# Pear tree Hill Solar Farm

## Response to the Examining Authority's Second Written Questions (ExQ2)

Document Ref: EN010157/APP/8.15

October 2025

Figure 1.2: Land Areas and Cable Routes Plan with Field Numbering System

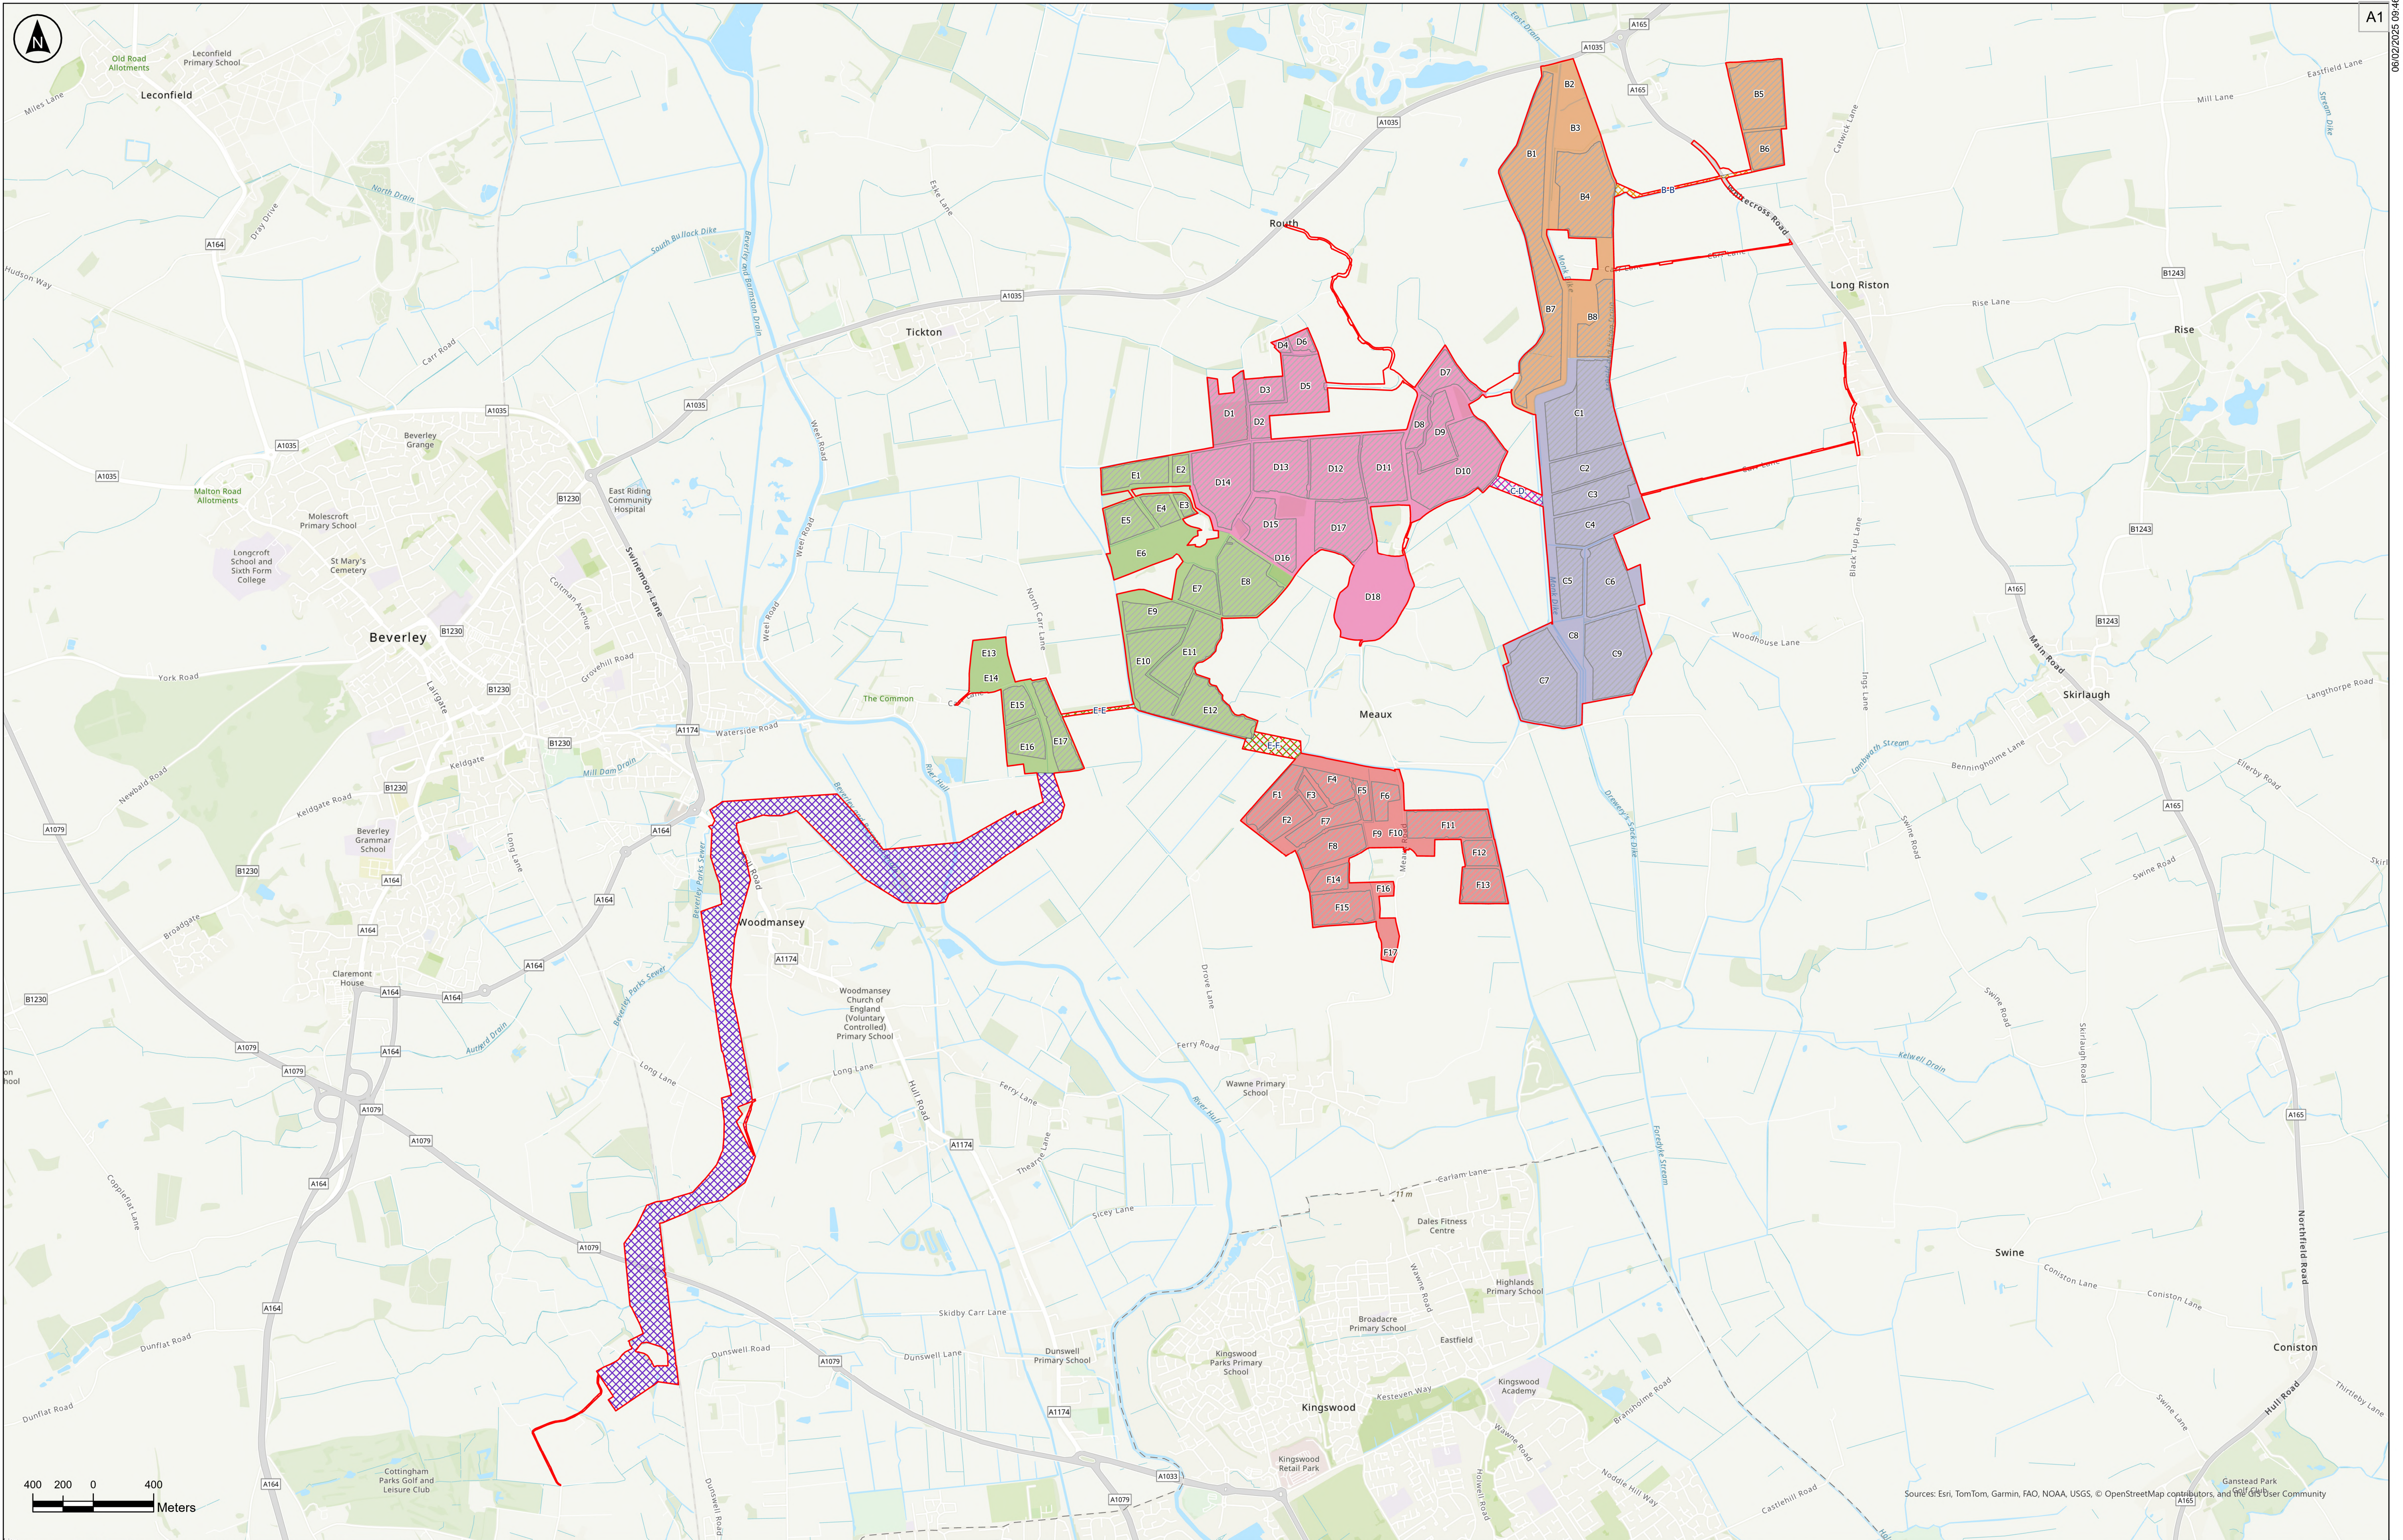
2.13.5	The applicant	<p><b>Access</b></p> <p>Regarding fields E15, E16 and E17, please clarify:</p> <ul style="list-style-type: none"> <li>a) how these fields would be accessed for construction purposes; and</li> <li>b) how these fields would be accessed for maintenance purposes (including replacement of parts), noting that there does not appear to be any internal access tracks on relevant plans linking these fields with, for</li> </ul>	<ul style="list-style-type: none"> <li>a) Fields E15, E16 and E17 are proposed to be accessed via an internal access track from Fields E9, E10, E11 and E12 for construction purposes. <b>ES Volume 3, Figure 3.5: Indicative Construction Layout Plan [EN010157/APP/6.3 Revision 3]</b> has been amended to show the proposed internal access track between Fields E9-E12 and Fields E15-E17 and is submitted at Deadline 3.</li> <li>b) Areas E15 to E17 will be accessed via Carr Lane, Weel, during the operation</li> </ul>

example, internal access tracks within fields E9 to E12?	<p>phase for occasional maintenance requirements. Vehicles will be restricted to LGVs only through Weel during the operation phase of the Proposed Development.</p> <p>The Applicant is exploring opportunities to maintain the temporary construction access for maintenance during operation but this is subject to further discussions with the landowner over potential conflicts in use</p>

Figure 14.3: Public Rights of Way and Long Distance Paths Within and Adjacent to the Proposed Development

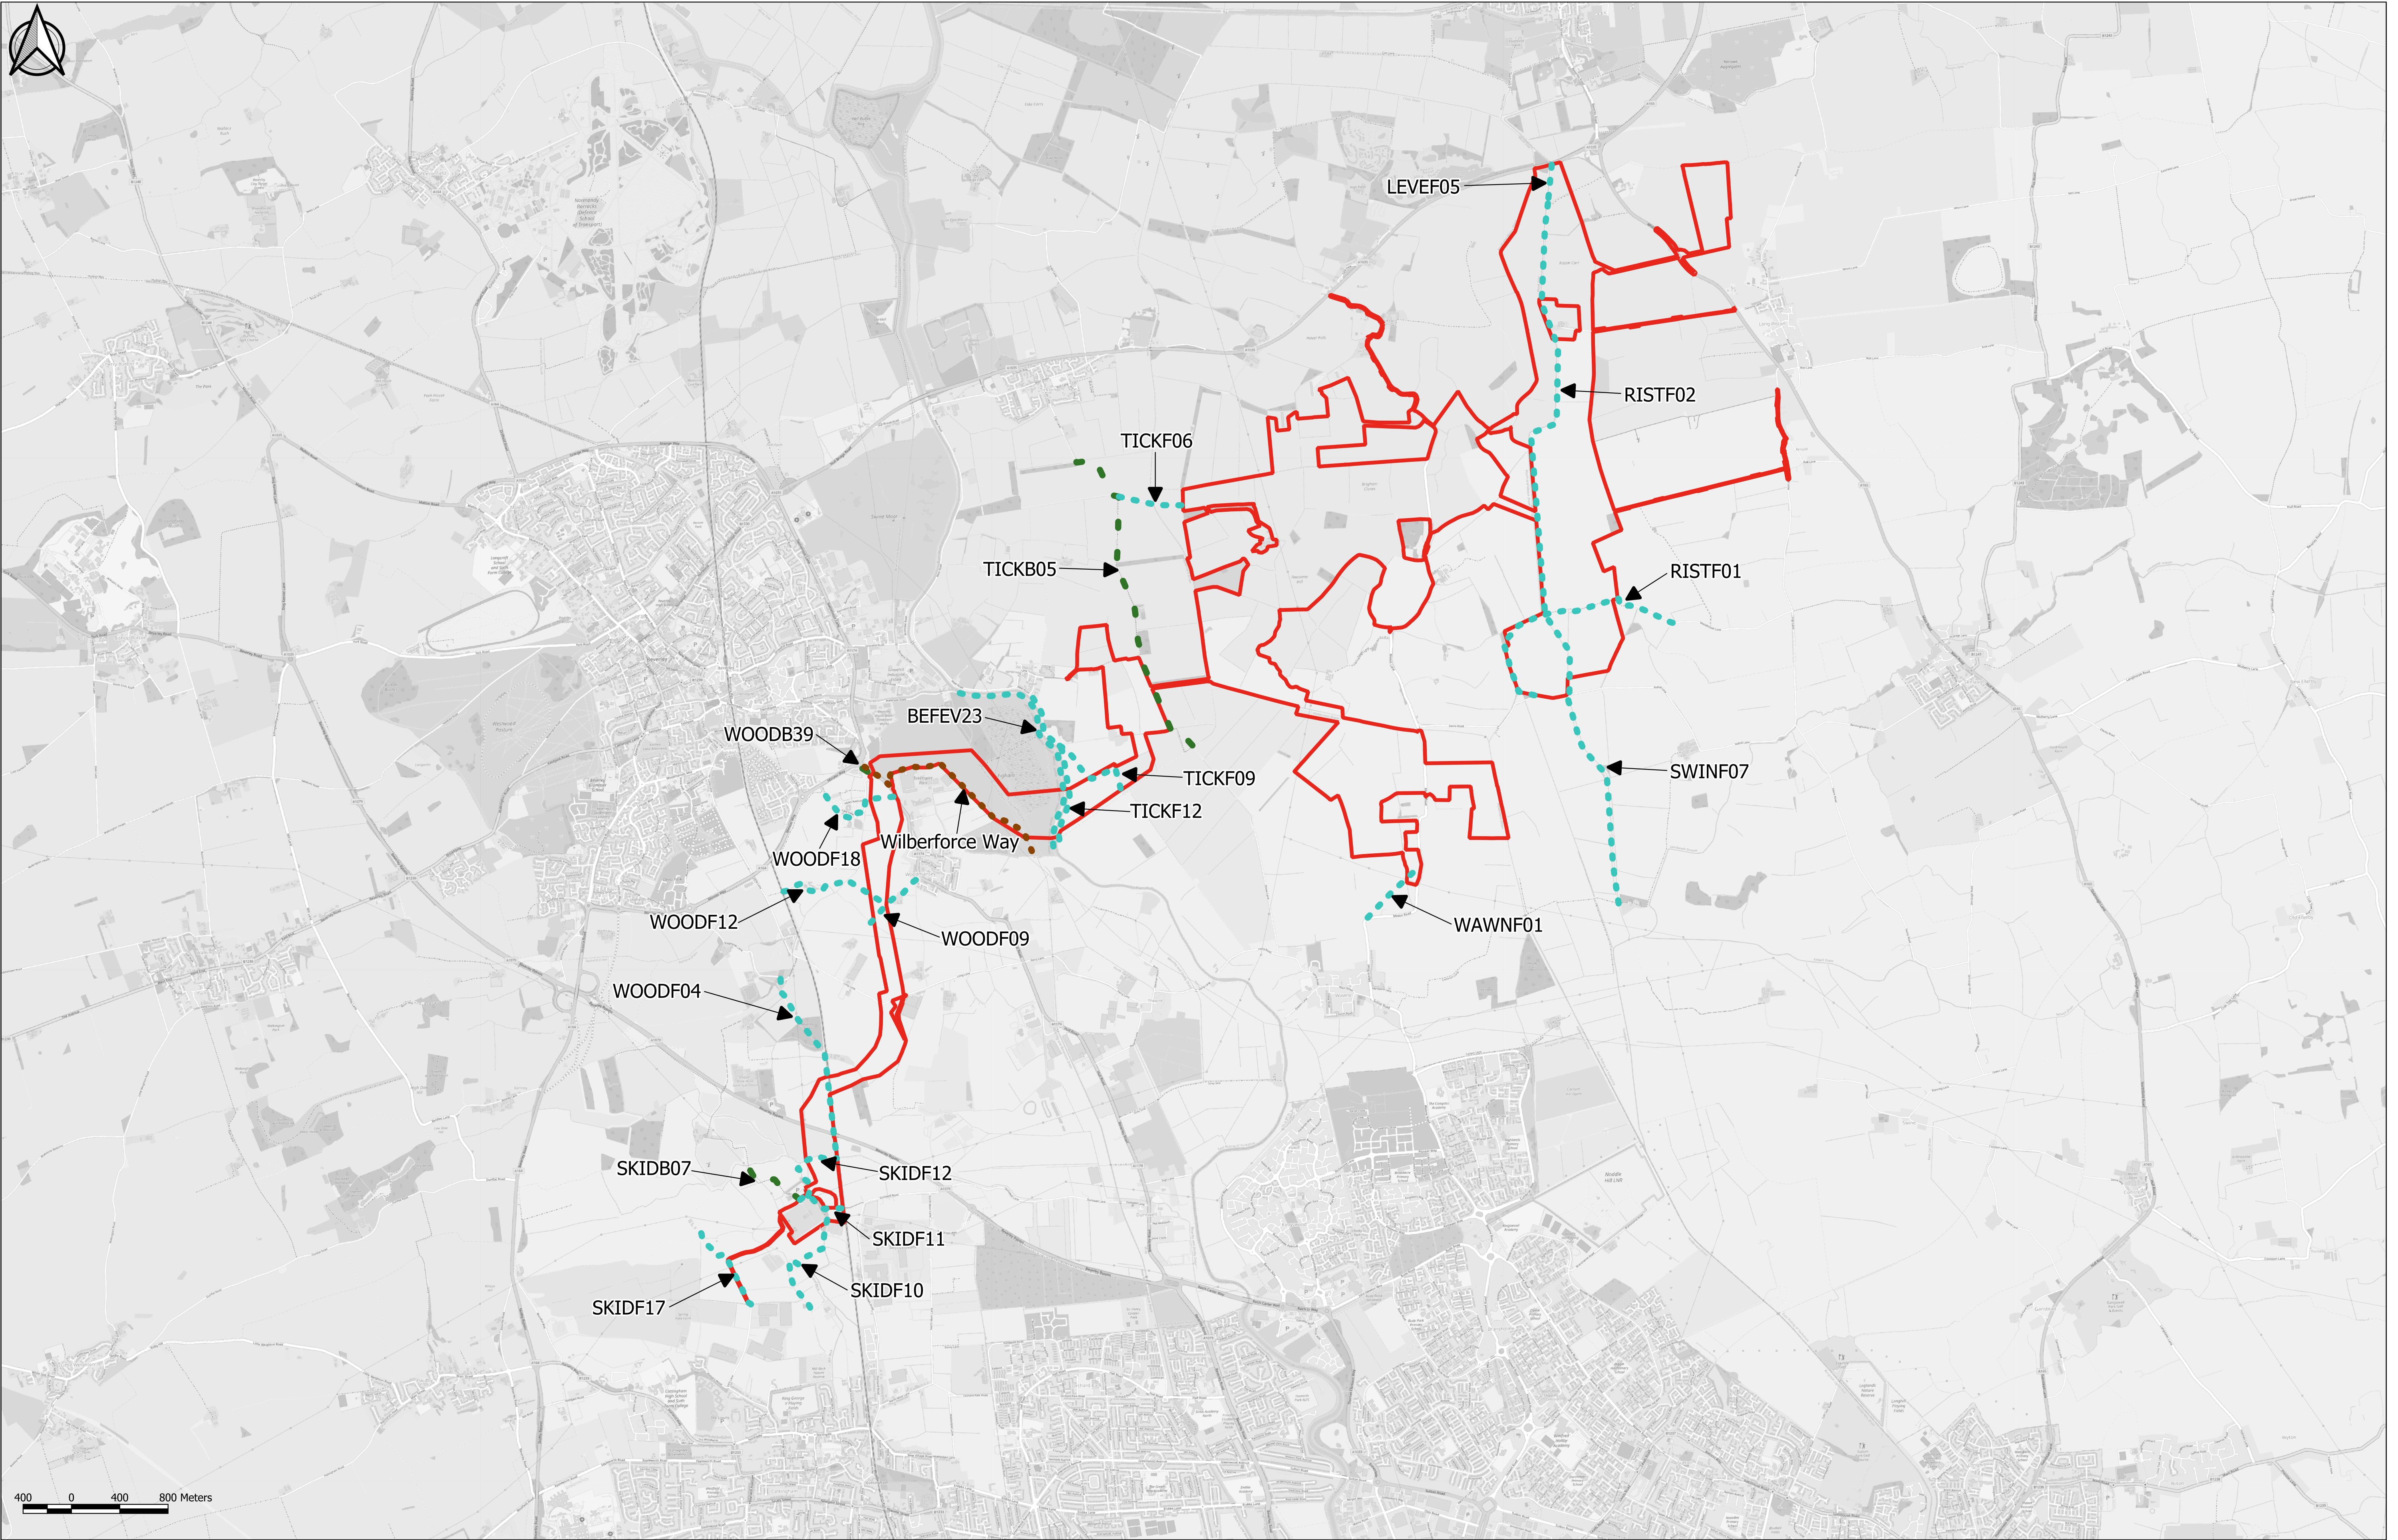
2.2.17	The applicant	<p>Sch 5, Part 2 –</p> <p>a) the ExA notes your response to ExQ1.2.66 [REP1-073]. However, please review the information given in ES Chapter 13 paragraph 13.9.1 [APP-049], noting that the Streets, Rights of Way and Access Plans [REP2-051], the outline Rights of Way and Access Management Plan Table 3-1 [REP2-144] and Sch 5,</p>	<p>a) Schedule 5 Part 2 of the <b>Draft DCO [EN010157/APP/3.1 Revision 7]</b> has been updated to remove reference to Riston Footpath No. 2 and Wawne Footpath No. 1 to align with <b>ES Volume 2, Chapter 13: Population [APP-049]</b> paragraph 13.9.1 which was updated at Deadline 2 via the <b>Environmental Statement Addendum [EN010157/APP/8.2 Revision 5]</b> to reflect that</p>

<p>Part 2 of the dDCO refer to measures the three cited footpaths would be subject to; and</p> <p>b) remove the additional spaces between the words 'Temporarily' and 'restricted' for Riston Footpath No. 2 and Wawne Footpath No. 1.</p>	<p>there will be no temporary restrictions to these PRoW. <b>ES Volume 2, Chapter 13: Population</b> will be re-submitted at Deadline 5.</p> <p>b) The requested amendment has not been made as per the response to part (a) of this question, this text in relation to Riston Footpath No. 2 and Wawne Footpath No. 1 has been removed from Schedule 5 Part 2 of the the <b>Draft DCO [EN010157/APP/3.1 Revision 7]</b> which has been submitted at Deadline 3.</p>
